**NRUG Clarification to DOCUMENT 8.3, The Northampton Gateway Rail Freight Interchange Order  
201X APPLICANT'S RESPONSES TO RELEVANT REPRESENTATIONS, 6 NOVEMBER 2018**

**NRUG: Further submissions regarding Rail Assessment, Rail Capacity and the failure to establish significant effects as required by the EIA Regulations.**

ROADE BYPASS

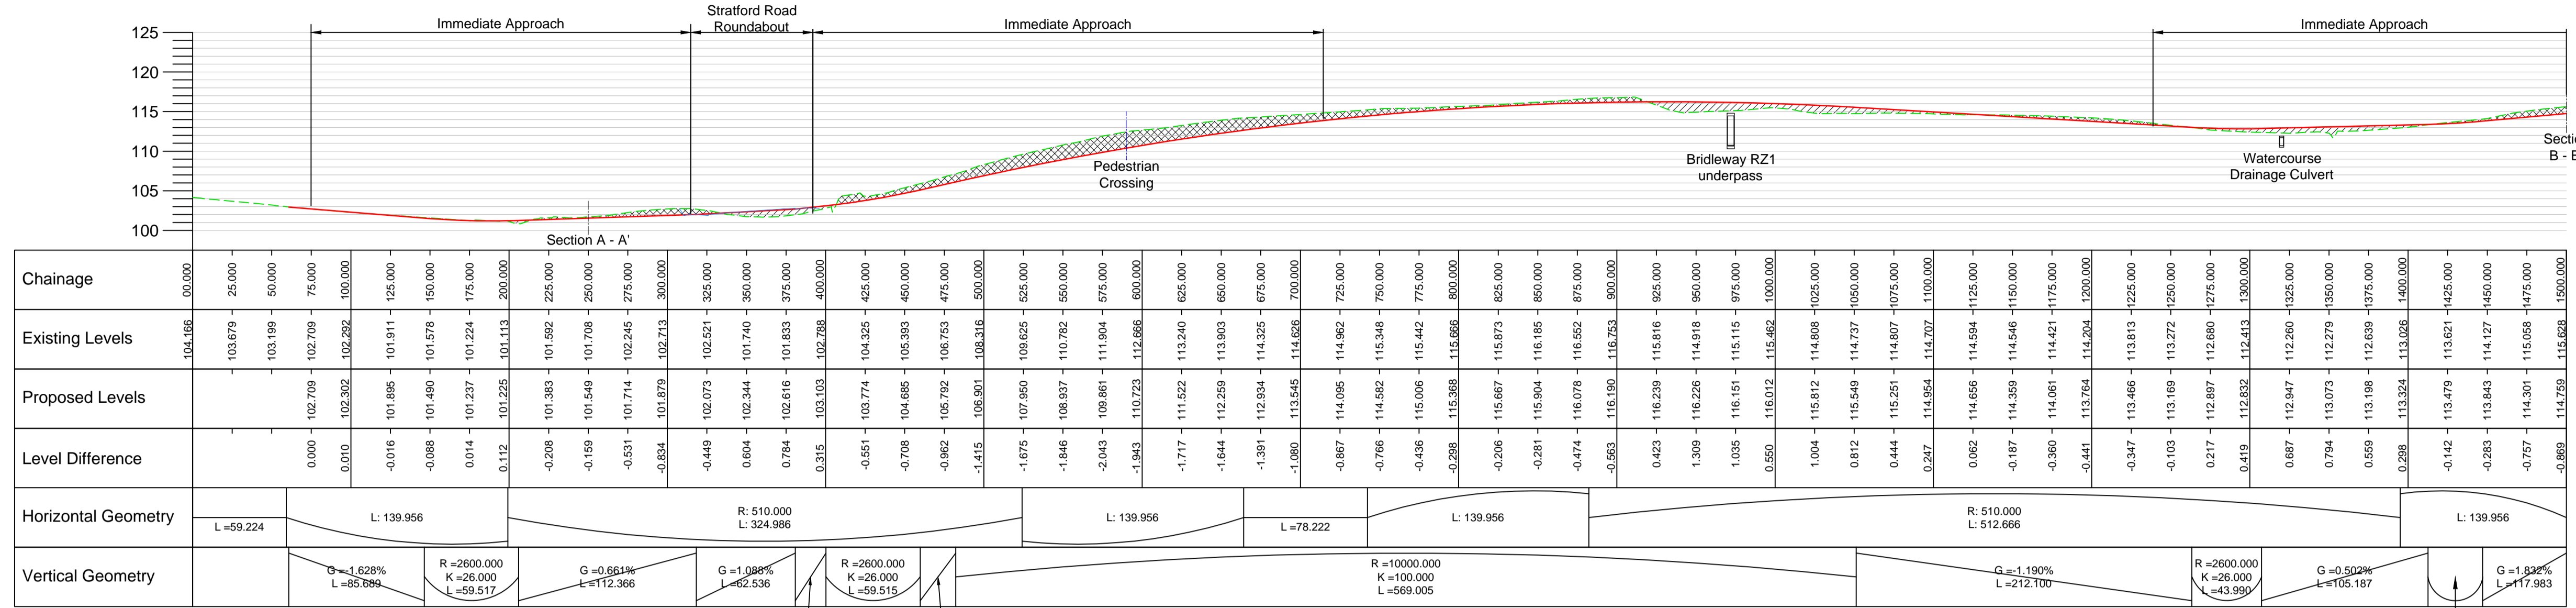
The representation by NRUG regarding the link road required for the proposed development (the so-called bypass) stated that the environmental effects had not been correctly assessed, NRUG stated:

“In EIA terms there is a simpler way of looking at this: part of the proposed development is to build a new road that takes 4245 HGV movements per day, and 9871 light vehicle movements per day created by the development. The developer then suggests the effects of the new road and this high traffic level to be “permanent beneficial” of “major significance”. This is not correct, on the contrary, building a road and then filling it with traffic created by the proposed development is not a beneficial environmental effect, it is a significantly adverse one.”

The response by the Applicant refers solely to the effects of traffic on the highway system, which is not the point in question, the point in question is the significant adverse environmental effects of the link road and the increased traffic caused by the proposed development. Under EIA methodology a new road carrying such a degree of new traffic cannot be determined beneficial.

Central to the evaluation is the fact that the “bypass” is in truth a link road built to serve the development because of the high traffic volumes caused by the development that cannot be absorbed by the existing road network. There is no alternative plan for a bypass solely to relieve existing traffic through Roade, and the Applicant is not making one, the Applicant's proposed link road is completely tied to the rest of the Development, and the introduction of vastly increased traffic level by that development. It needs to be evaluated as such.
